**Valley of the Winds (SSD-10461) - Muswellbrook Shire Council Objection**

Reference is made to the 'Valley of the Winds Environmental Impact Statement and associated documentation' (Ramboll, April 2022) (EIS).

Figure 10 | Transport Route

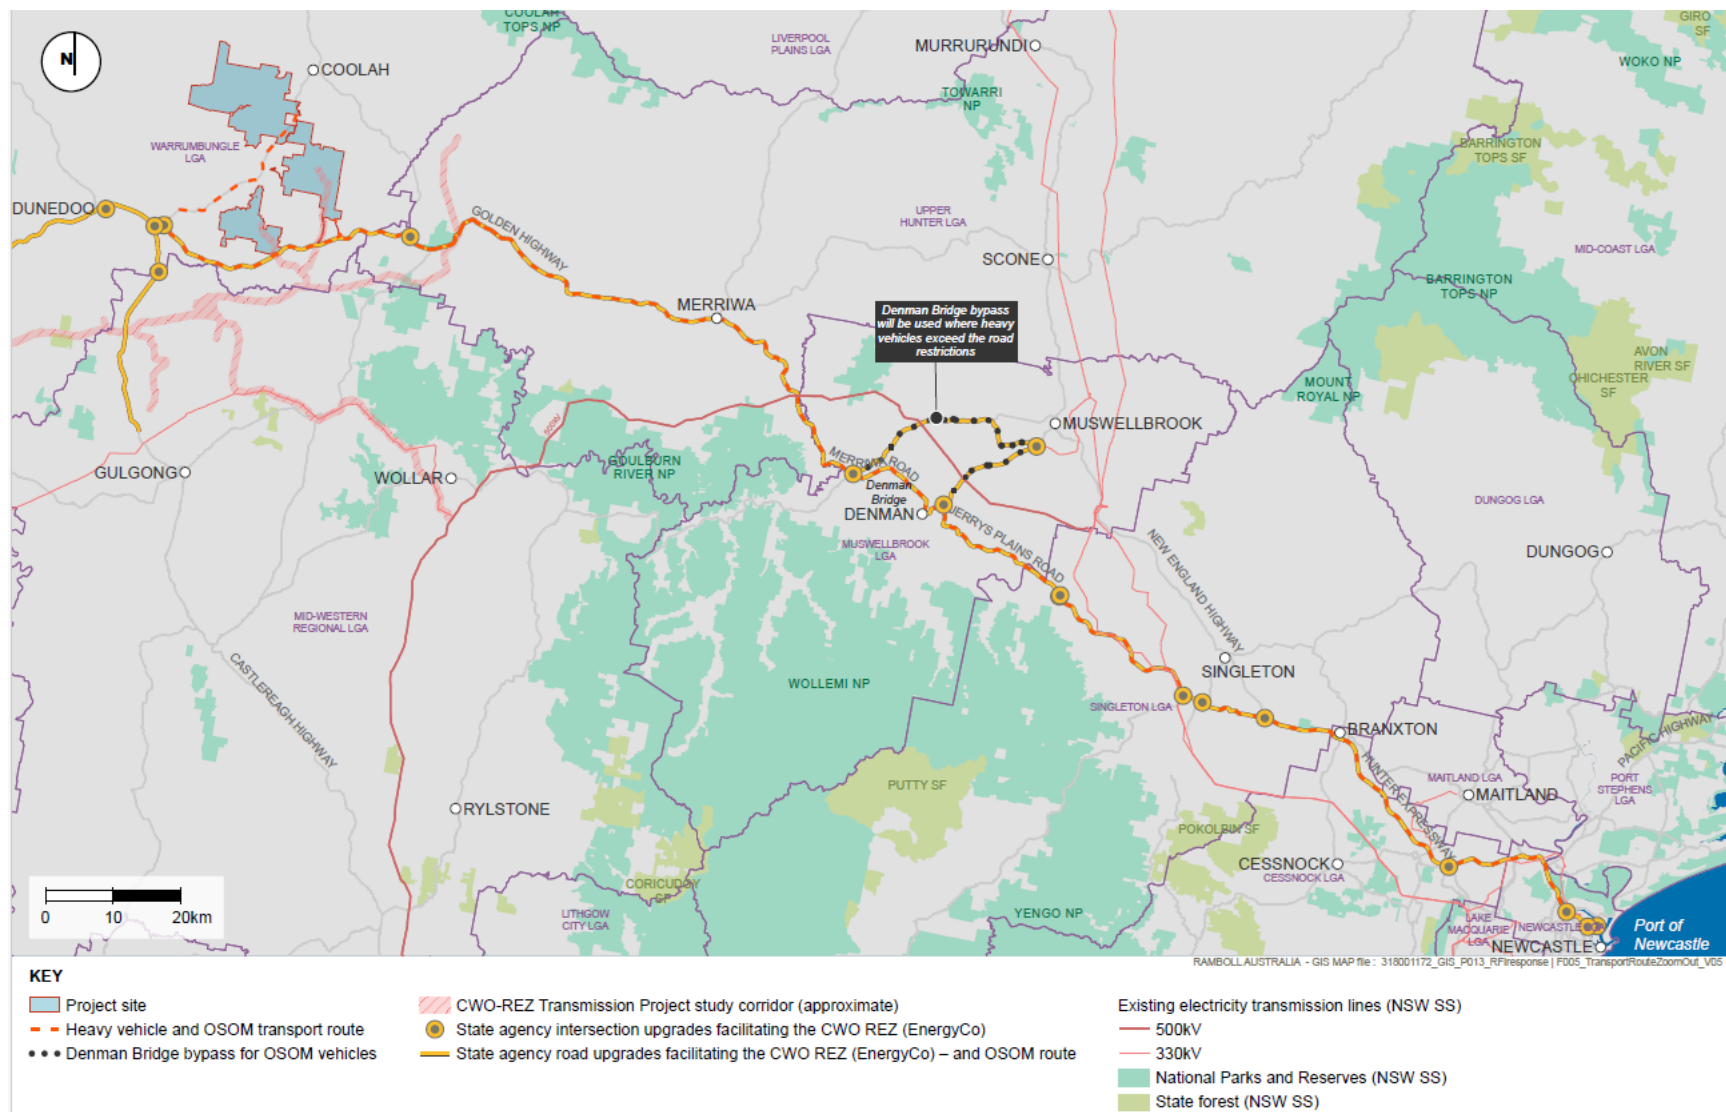
*"Vertical and horizontal limitations of the Denman Bridge truss structure, located at Denman Hunter River, could be too short and narrow to facilitate the Over Size Over Mass movements (OSOM) . As such, alternate routes for the OSOM movements may need to be investigated to use the New England Highway via Scone."*

Alternate route investigations have not been included in the assessment. Furthermore, the road between Scone and Merriwa would still require access along Bengalla Link Rd, Wybong Rd and Kayuga Rd until the Muswellbrook Bypass is complete.

Council Officers have become aware that there are several projects currently in the planning system for the CWO REZ that are proposing to use Council owned local roads to transport wind farm components to site. Specifically, the use of Bengalla Link Road, Denman Road and Edderton Road (see **Figure 1**).

4. Use of Council local roads (as opposed to State roads) is a constraint caused by the Denman Road bridge crossing of the Hunter River (height limit restricted). Note that the proposed 100-110m blade for Barney's Reef and Spicer's Creek may also be constrained by the newly constructed Mangoola overpass on Wybong Road.

- A Detailed Route Analysis considering road furniture, geometry, load limits, safe sight distance, private property and Council road impacts, turning circles by a suitably experienced and practicing consultant is to be provided to Council.
- Written consent of the impacted private property owners along the route, including any written correspondence between parties and contact information.
- A joint dilapidation survey with Council.
- Structural assessment of all drainage structures along the proposed route that has not had a recent condition assessment with proposed design loads exceeding existing load compliant traffic along the proposed road route.
